**Alan Varela, Director**

December 20, 2024

**Re: Sawmill Building A at 1904 Bellamah Av. NW  
Erosion and Sediment Control Plan  
Engineer's Stamp Date 12/4/24 (J13E044A)**

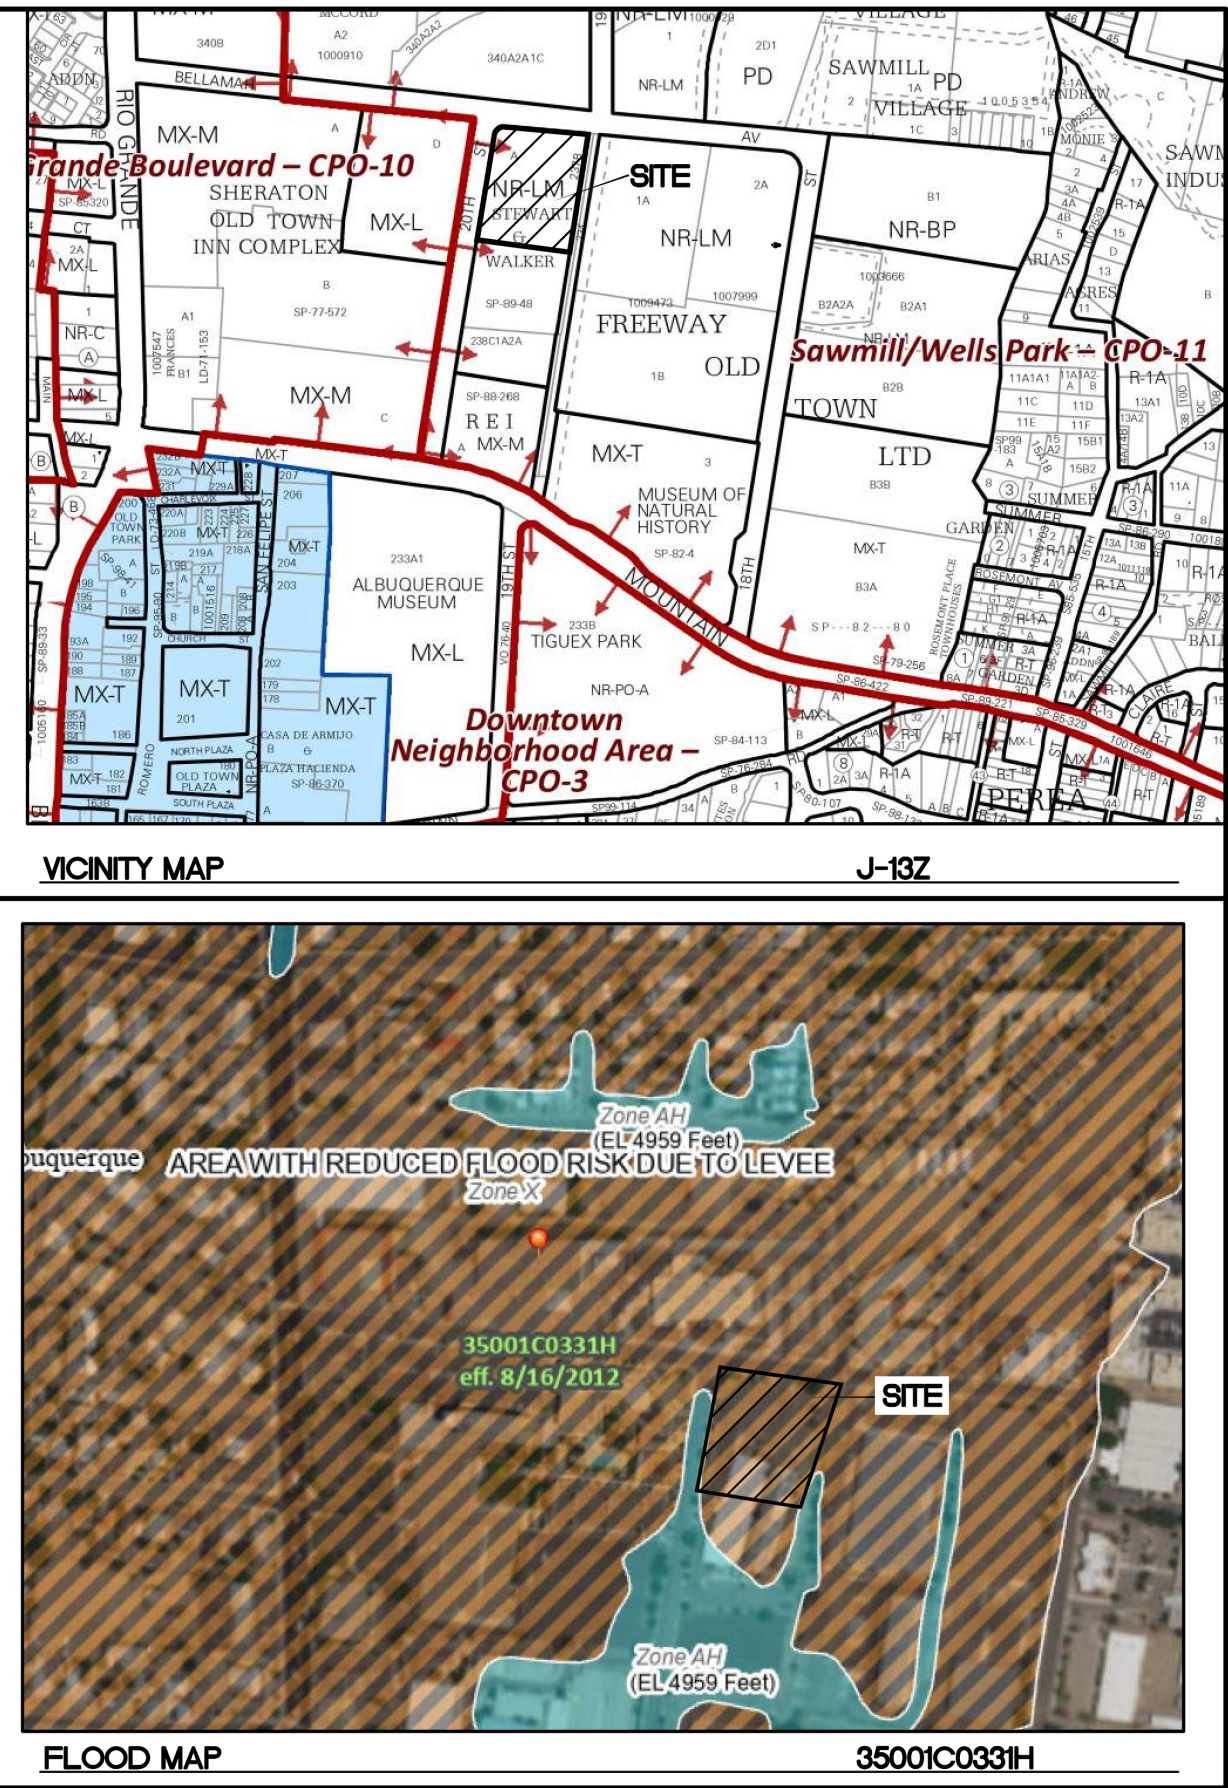
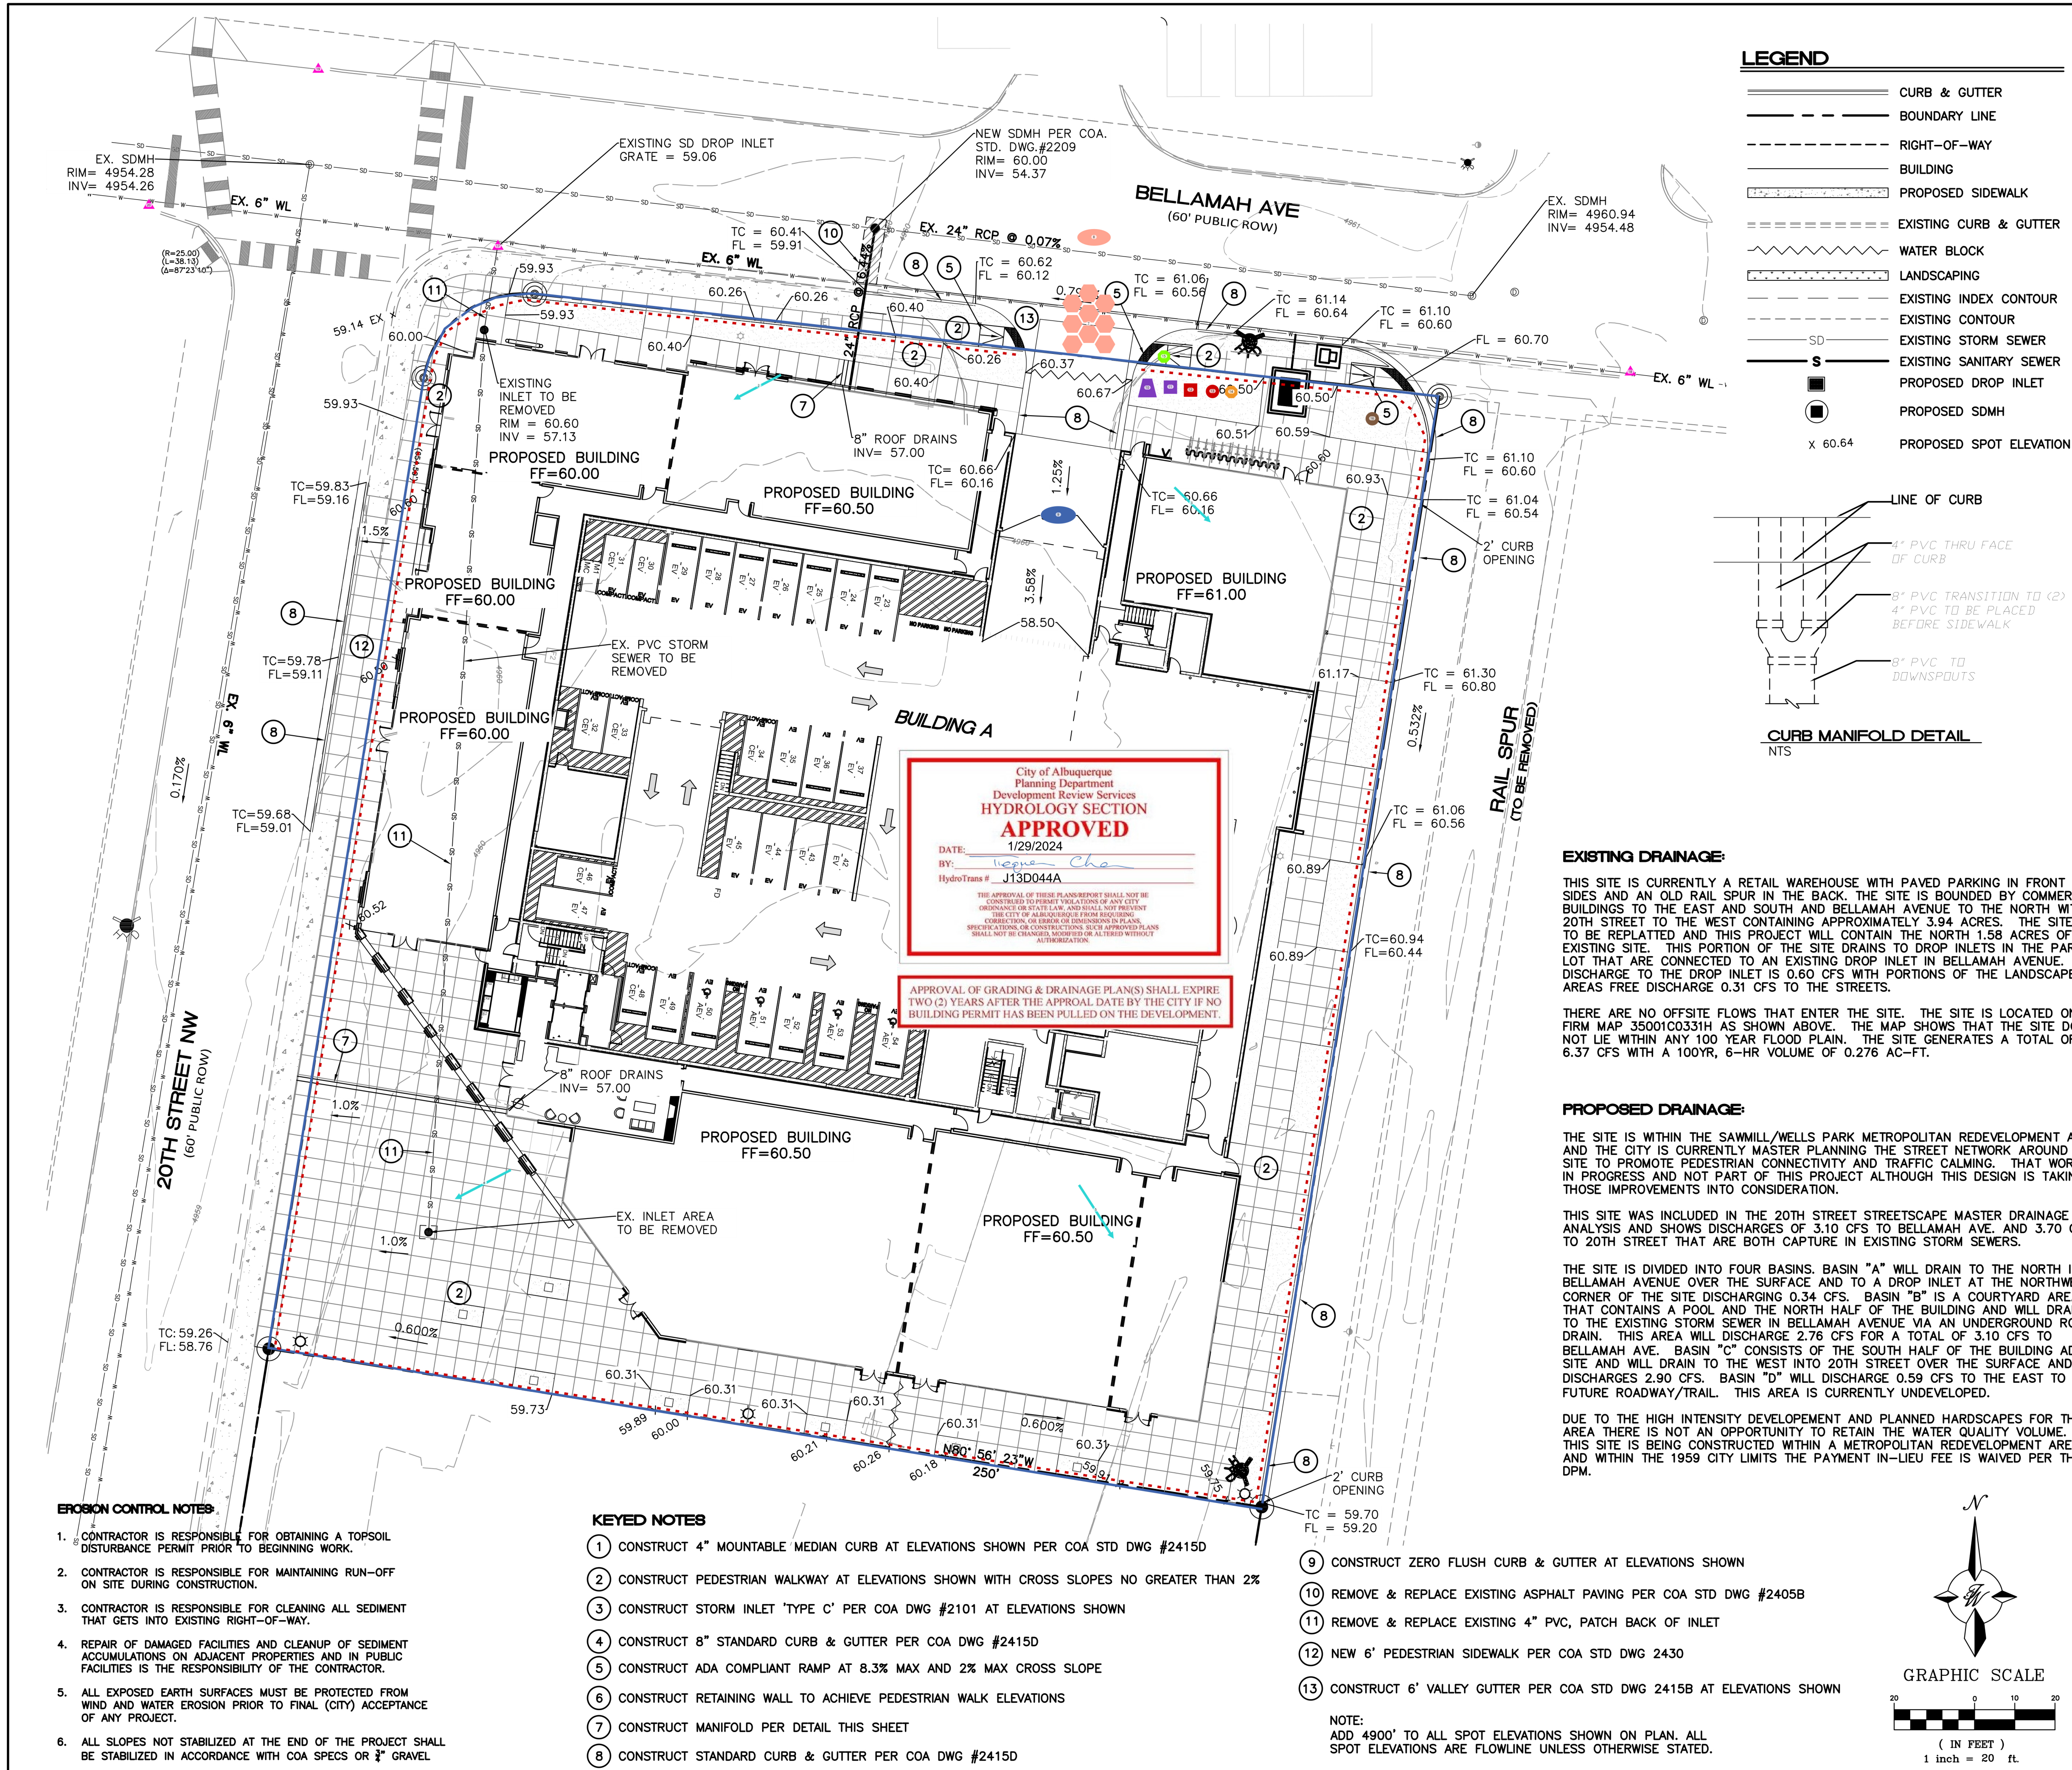
8. Identify controls on the ESC Plan to minimize the exposure of PCB-containing building materials, including paint, caulk, and pre-1980 fluorescent lighting fixtures, to precipitation and stormwater. Separate work areas from non-work areas and construct a containment area so that all dust or debris generated by the work remains within the protected area.
